# Appeal Decision

**Appeal Ref: APP/R5510/W/21/3283965**

**Ruislip Nursing Home, 173 West End Road, Ruislip HA4 6LB**

- The appeal is made under section 78 of the Town and Country Planning Act 1990 against a refusal to grant planning permission.
- The appeal is made by Mr Cader, Ruislip Nursing Home against the decision of the Council of the London Borough of Hillingdon.
- The application Ref 19817/APP/2021/913, dated 9 March 2021, was refused by notice dated 21 April 2021.
- The development proposed is new outbuilding in rear garden.

**PROPOSED SIDE ELEVATIONS**

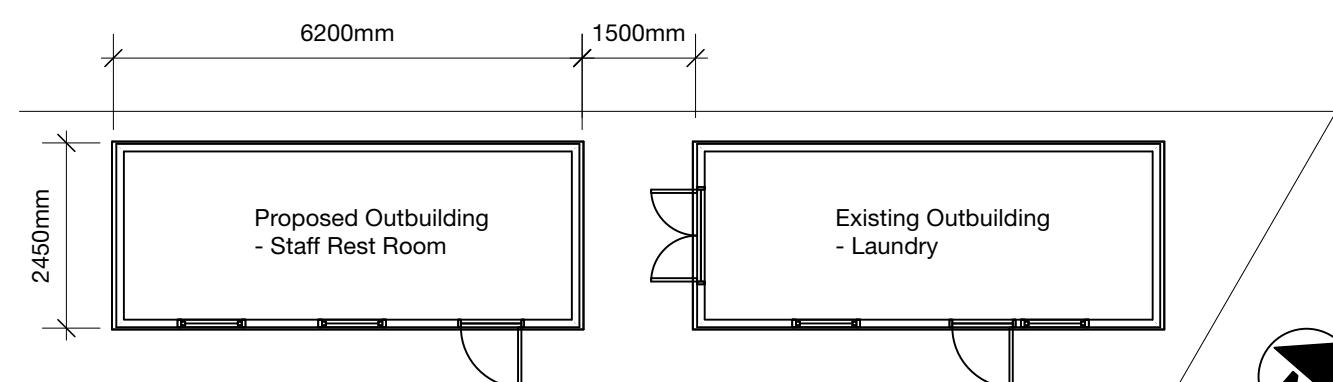
8. The flat roof design and limited detailing would additionally result in a bulky and somewhat plain appearance, and I consider that the timber cladding to a structure of this scale would stand out incongruously against the detailing and more traditional materials and appearance of the host building. While I acknowledge that it would be of very similar form and appearance to the laundry outbuilding, its closer proximity means that the visual contrast against the host building would be much more pronounced.

**PROPOSED SITE PLAN**

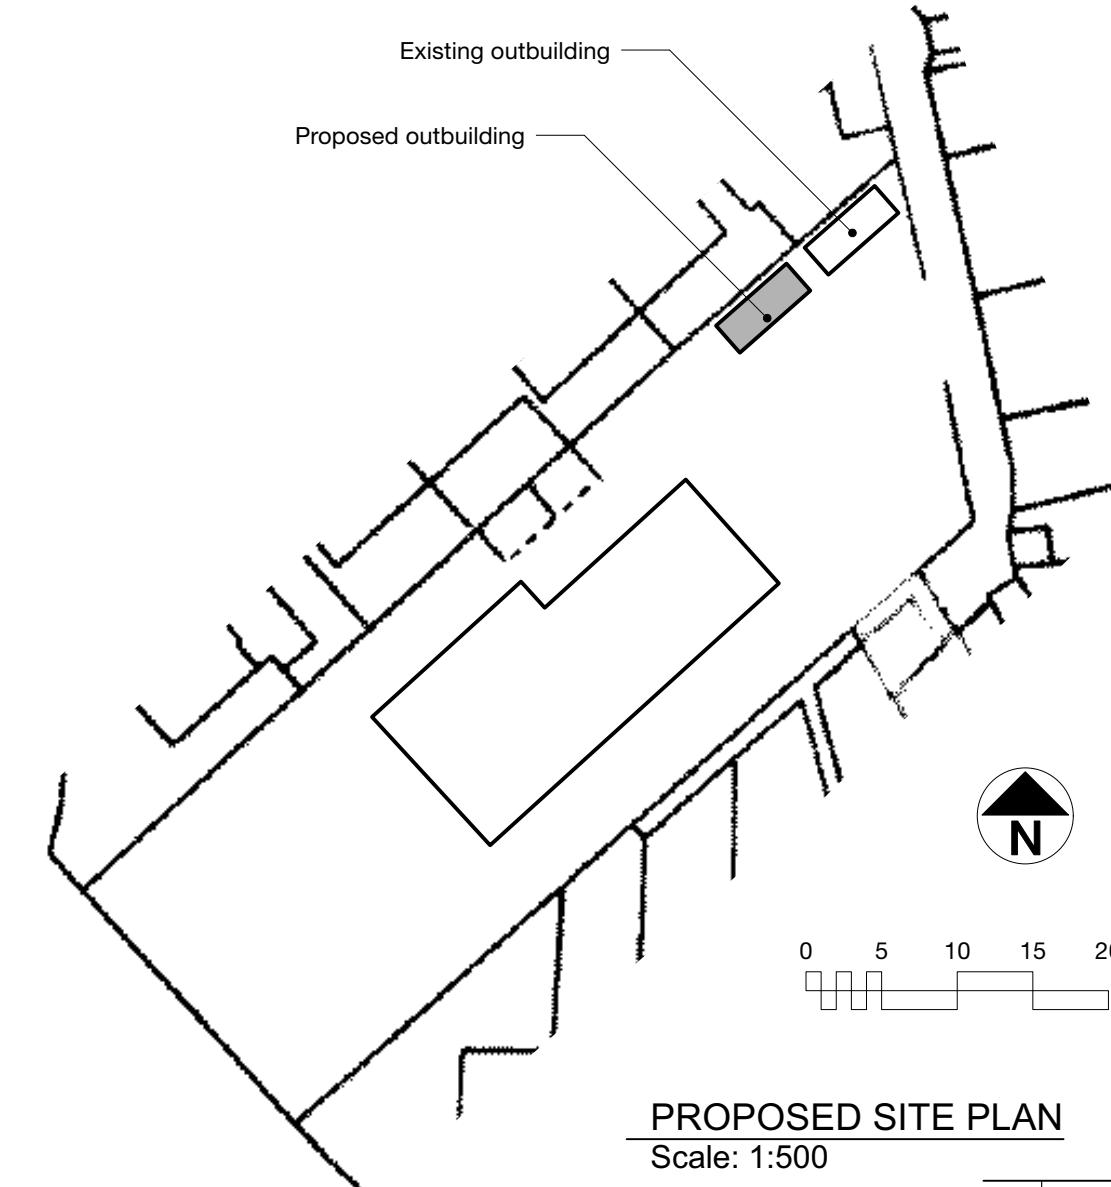
7. The proposed outbuilding would be positioned between an existing outbuilding used as a laundry and the rear of the appeal building, and would in part replace a landscaped bed close to the boundary of the site with 37 Northdown Close. The proposed site plan drawing does not illustrate the existing extensions to the appeal building, but they are shown on the existing site plan and from my observations at my visit it is apparent that the development would be close to the rear of the building. It would also be close to the existing laundry outbuilding, and the resulting impression would be of a near continuous spread of built form extending along the depth of the site from the rear of the building. In my judgement, this would exacerbate the visual impact of the additional coverage of the site by built form, and together with the existing outbuildings would give a cluttered appearance and cause further erosion of the remaining setting to the Locally Listed Building.
